Our ref: F2019/00387

**Re: SSD-10285 – Royal Randwick Racecourse – Leger Lawn Development**

I refer to your request for advice notice dated 13 November 2019 in regard to the Royal Randwick Racecourse – Leger Lawn Development State Significant Development (SSD-10285). The proposal is for the construction of a two-storey multi-purpose building (to be known as the Winx Stand), located at the southern end of the existing QEII Grandstand.

DRAWING  
GROUND FLOOR - MIDDLE AREA AND WESTERN ENTRY

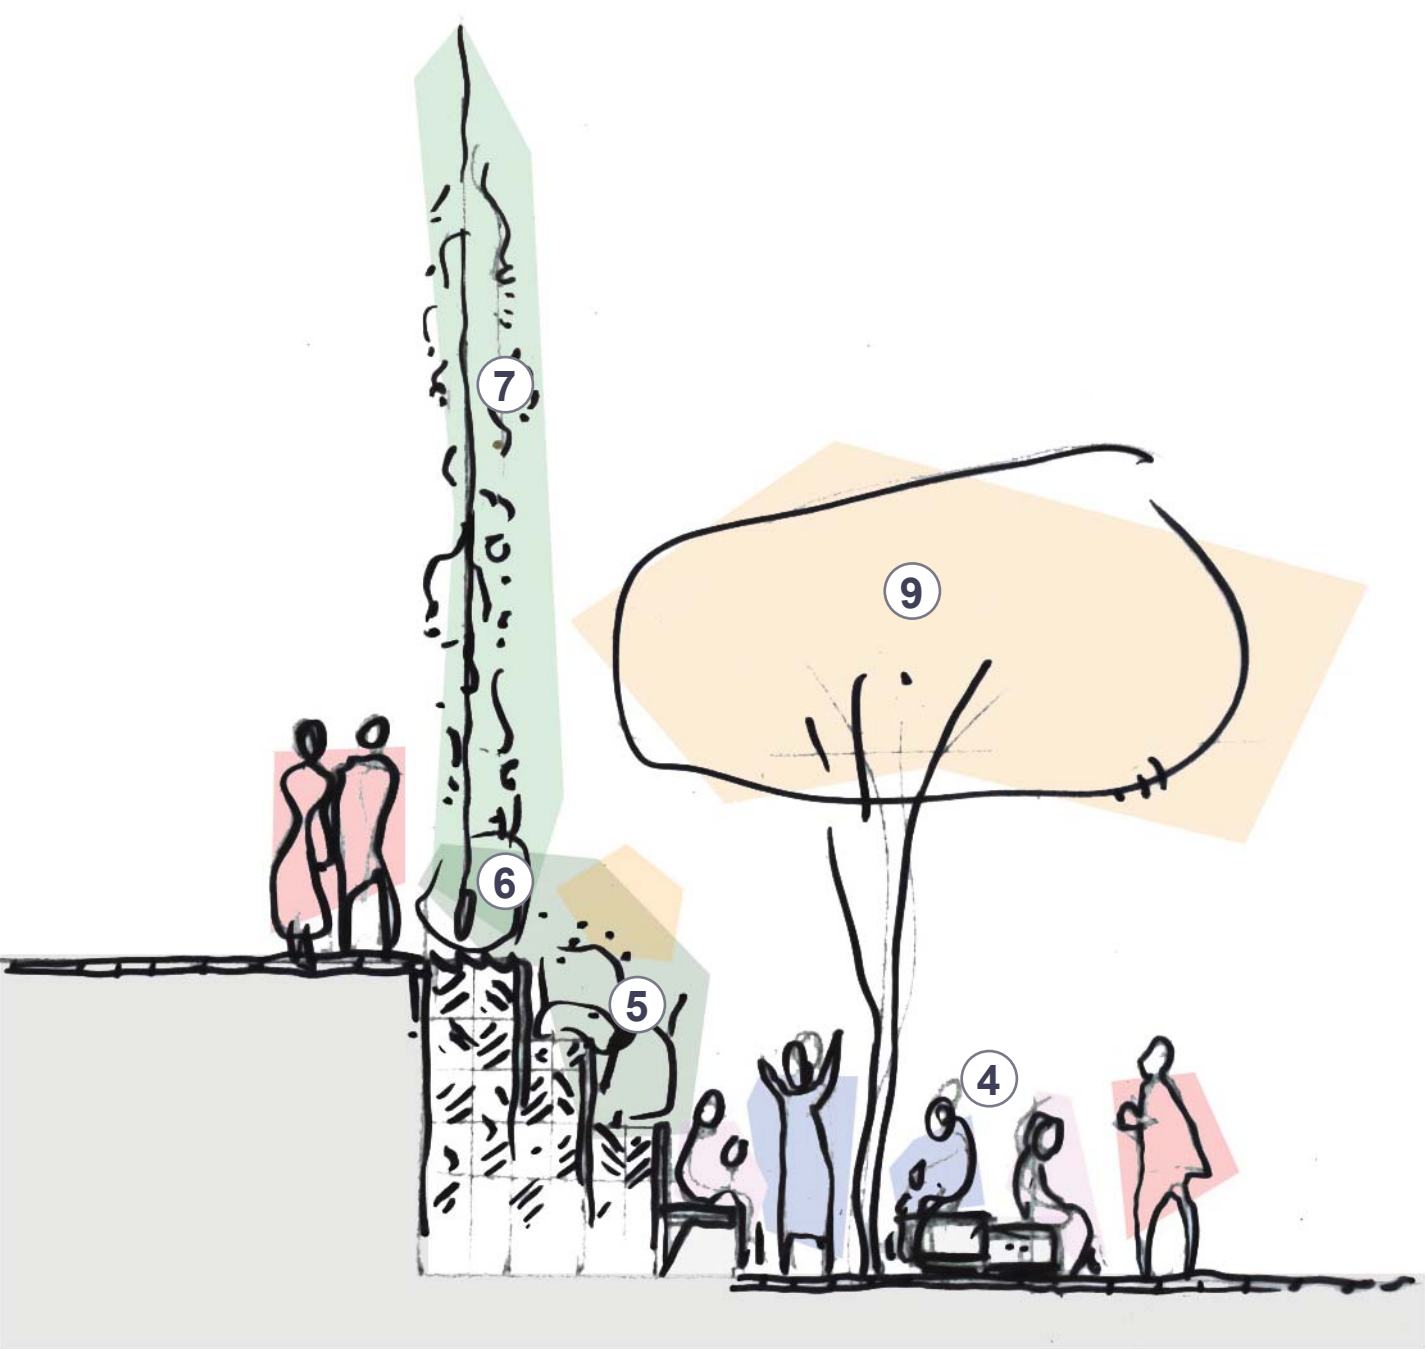
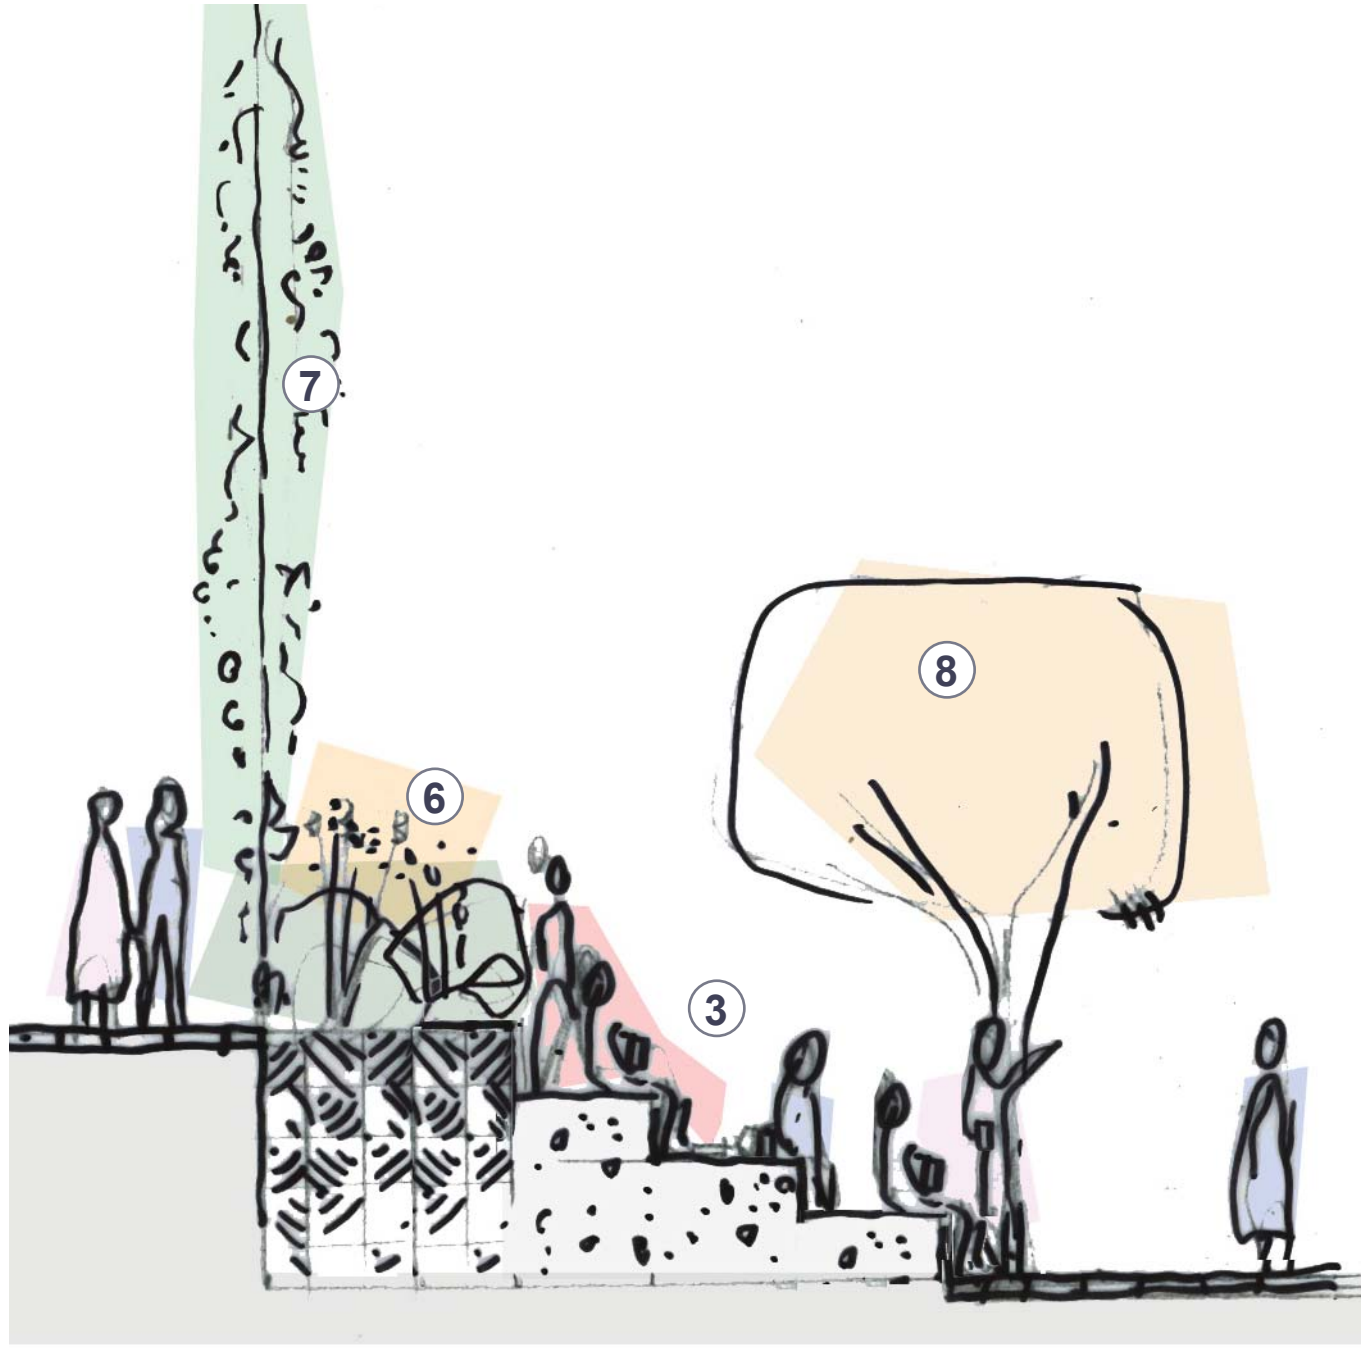
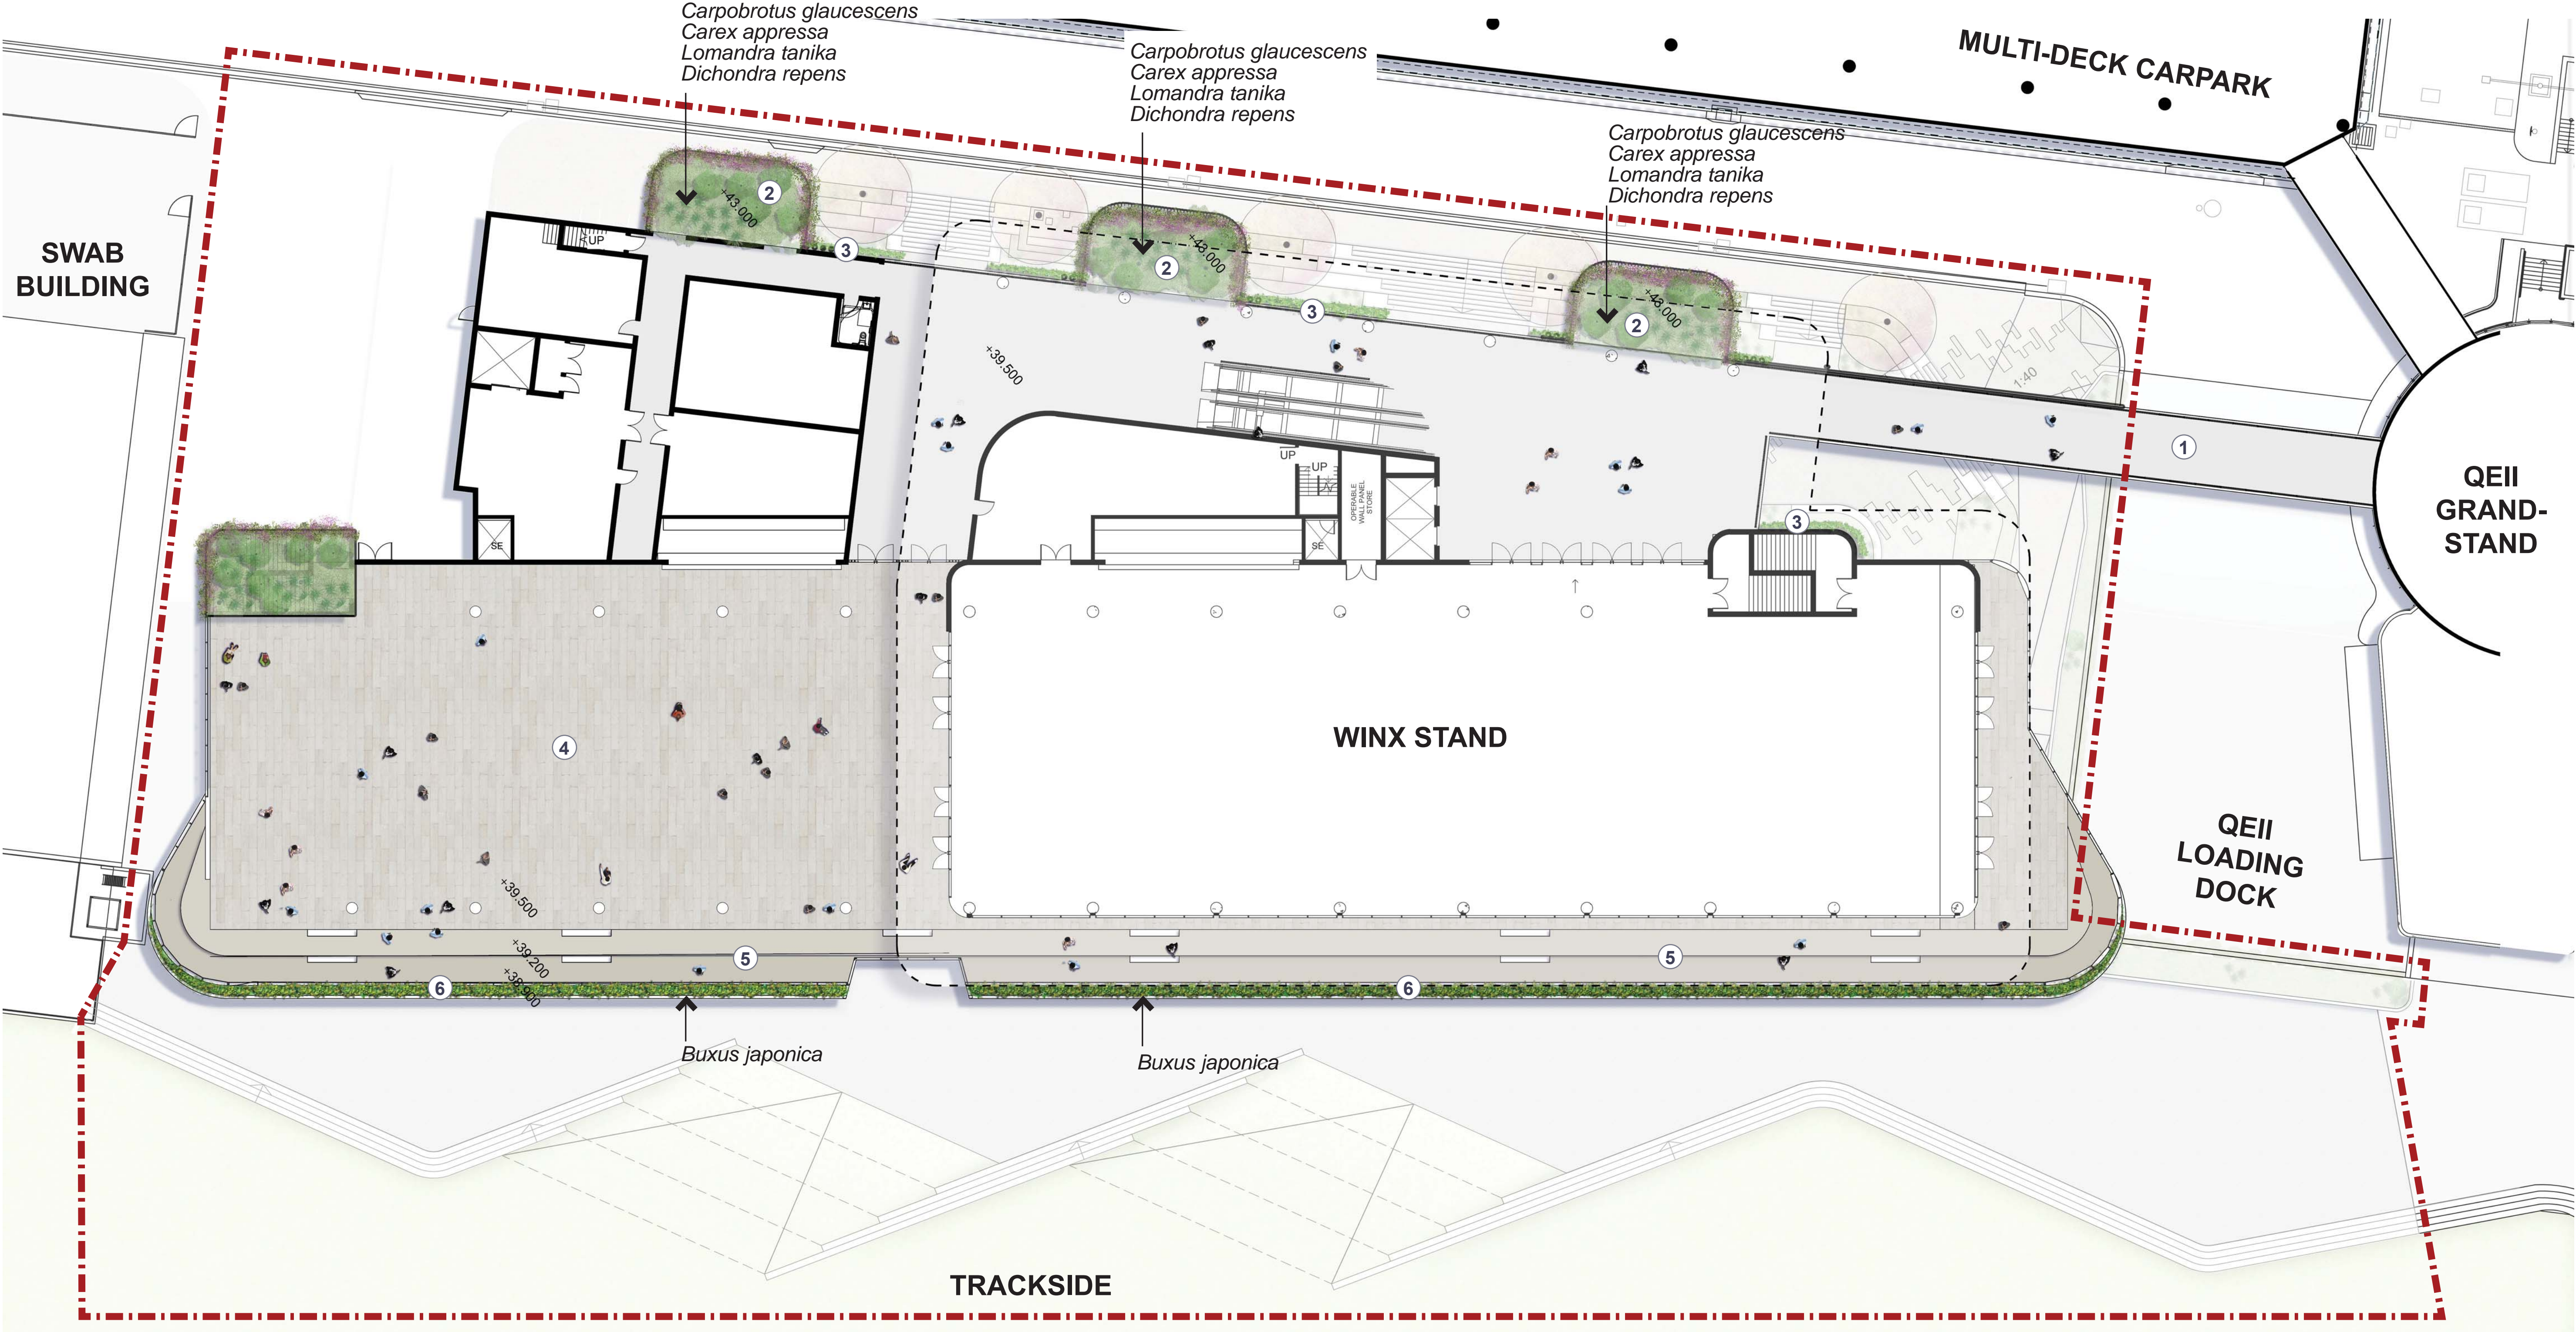
More specifically, the use of grassed ramps between the terraced landscape area and the forecourt of the Winx Stand will require gradients and fixtures/fittings that are compliant with the Disability Discrimination Act 1992. The overall design and construction of the proposed development must be made compliant with all aspects of the Disability Discrimination Act.
